MEMORANDUM

DATE: September 27, 2024

SUBJECT: Monument Ridge East
RE: Traffic Impact Study
Response to CDOT Comments Memorandum
LSC #S234450
EPC PCD File Nos. P245, P246, SP241

Following are the LSC Transportation Consultants, Inc. responses to the September 10, 2024 Comment Letter from CDOT – Region 2 – Traffic & Safety – Permits regarding the Monument Ridge East project.

Figure 10

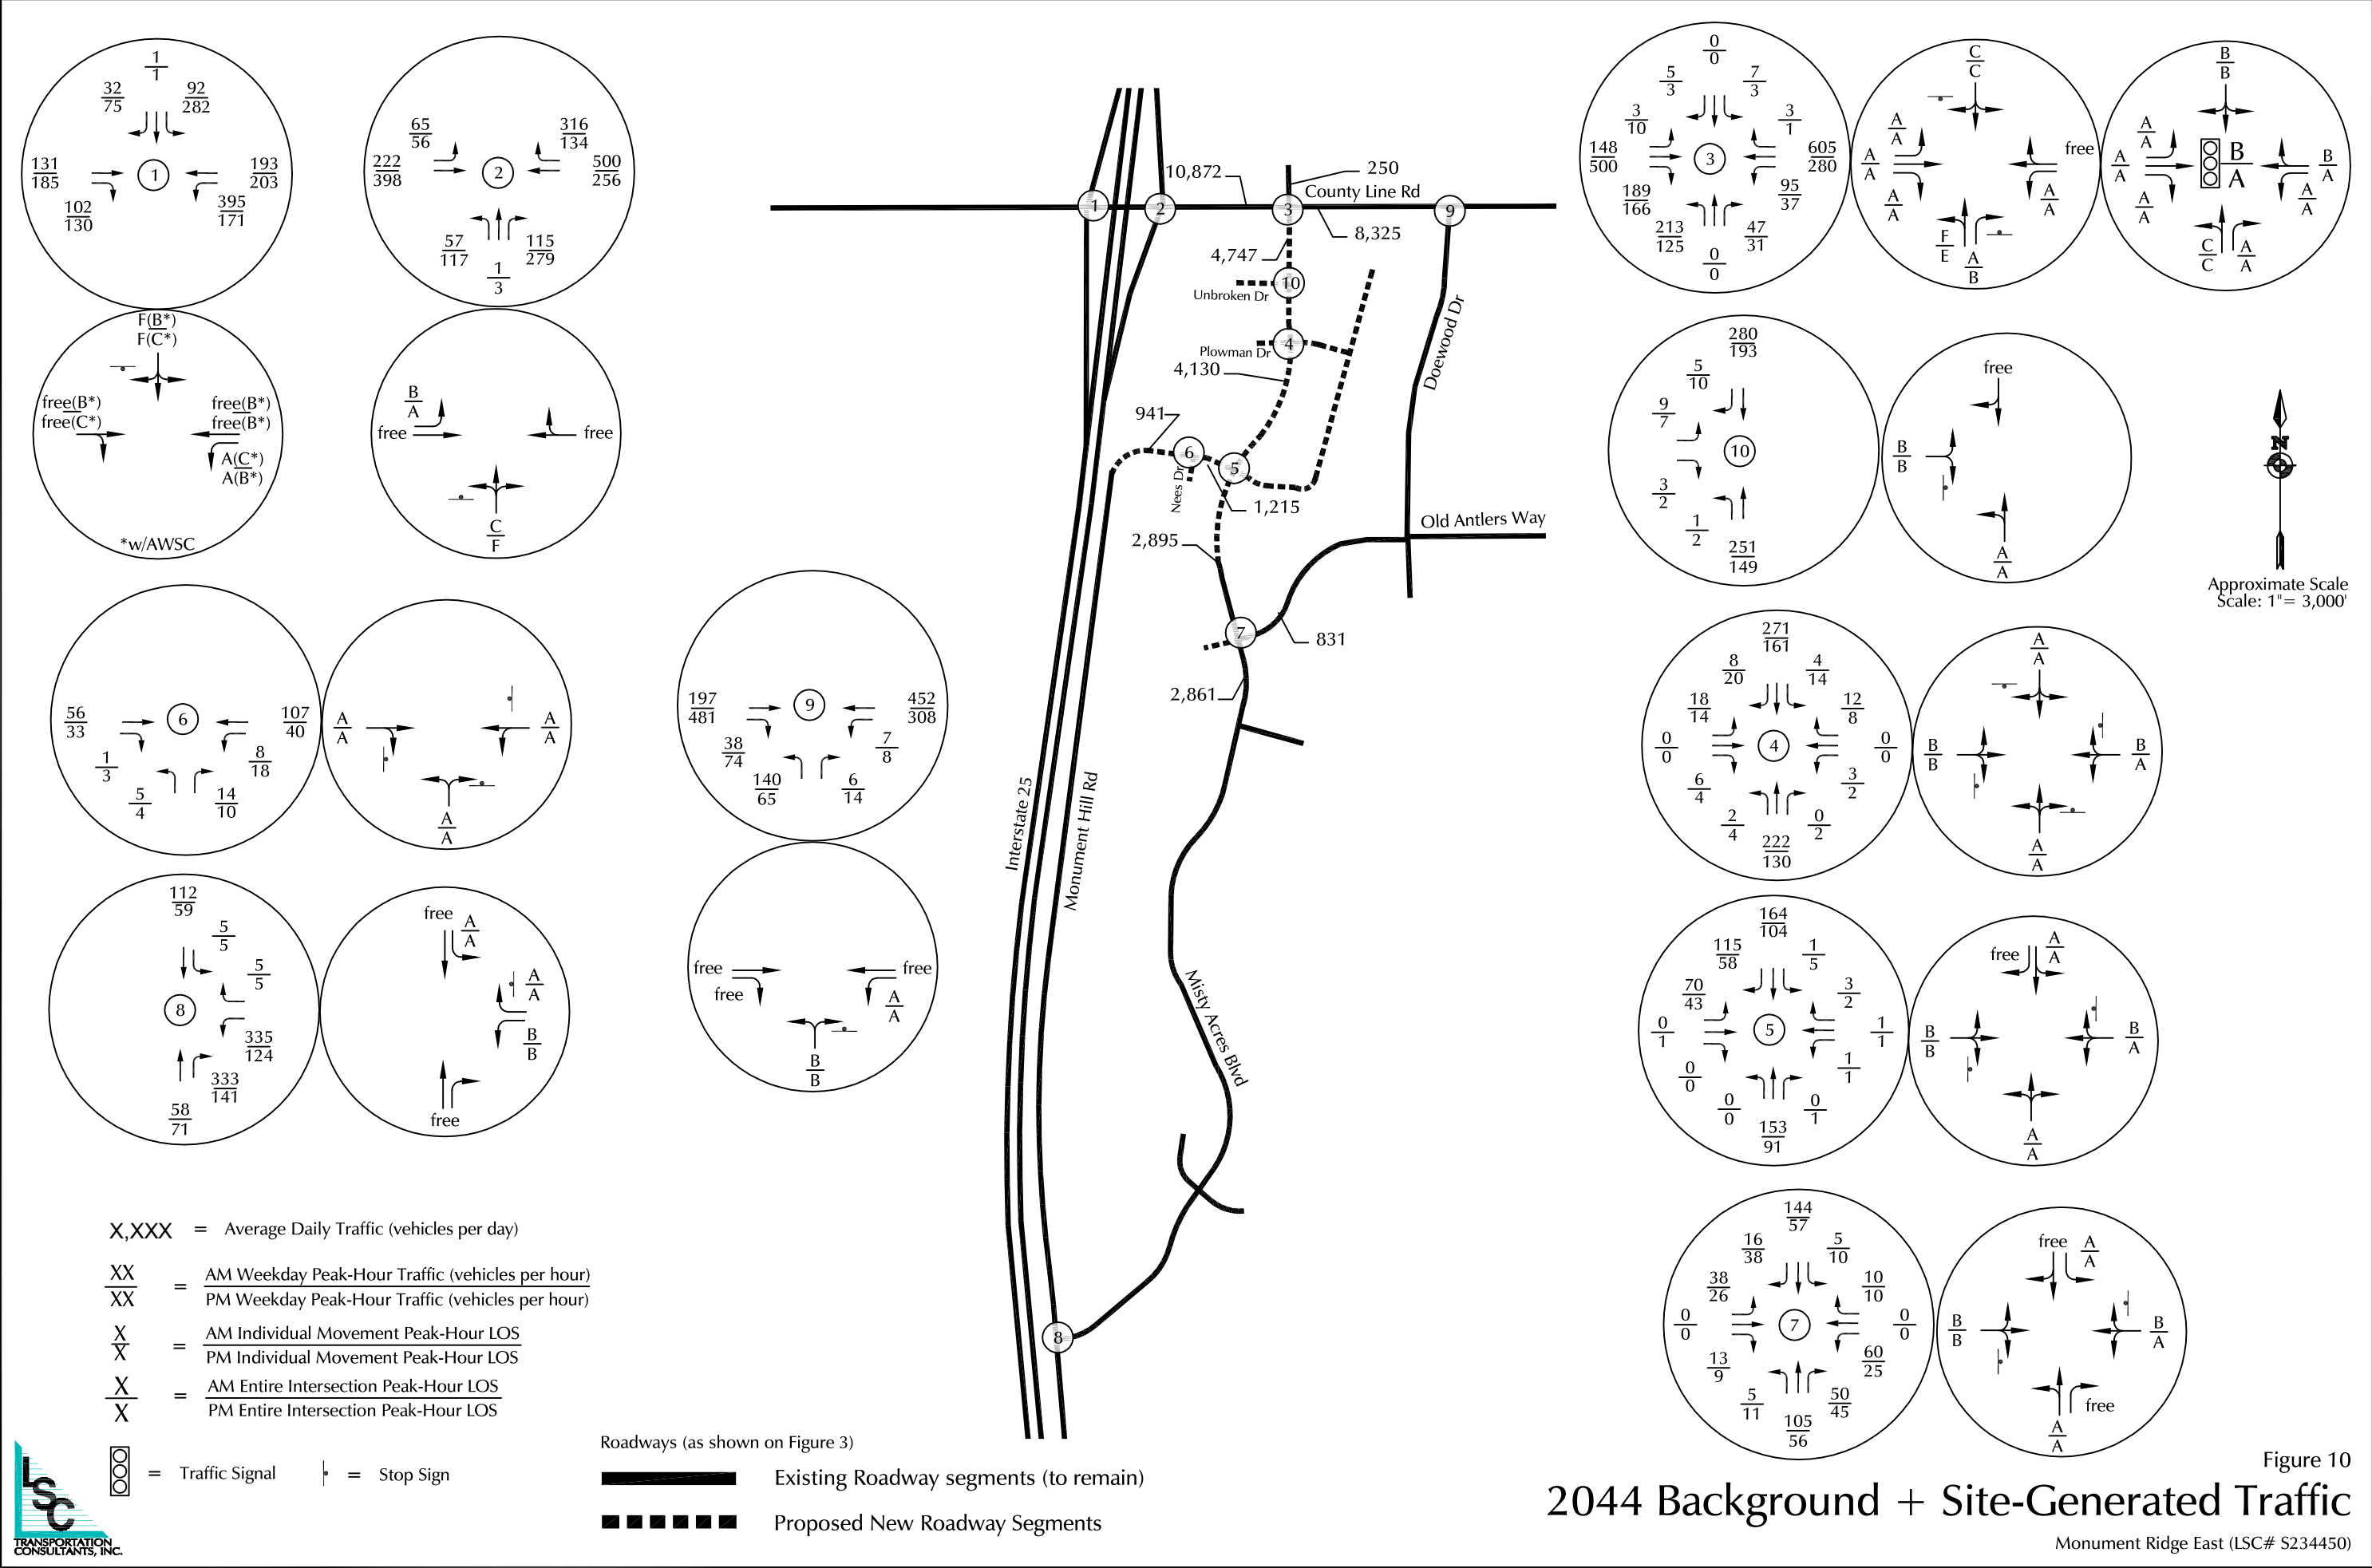
Per CDOT direction from the meeting on September 25, 2024, a separate, exclusive, northbound-right turn lane at the I-25 northbound off-ramp intersection with County Line Road has been added. The following presents updated level of service and vehicle queuing analysis at the northbound-ramp intersections with County Line Road. The analysis continues to show, as in the August 2024 TIS, the need for all-way stop control (AWSC) at the I-25 southbound ramp intersection to mitigate a projected LOS F for the southbound approach with TWSC.

Volumes used in this analysis are shown in Figure 10 of the August 6, 2024 TIS report (copy attached for reference). The Long-Term “Total” (2044 Background plus Site-Generated) AM and PM peak-hour traffic volumes have been analyzed.

Revised per the CDOT comment letter and September 24th meeting.
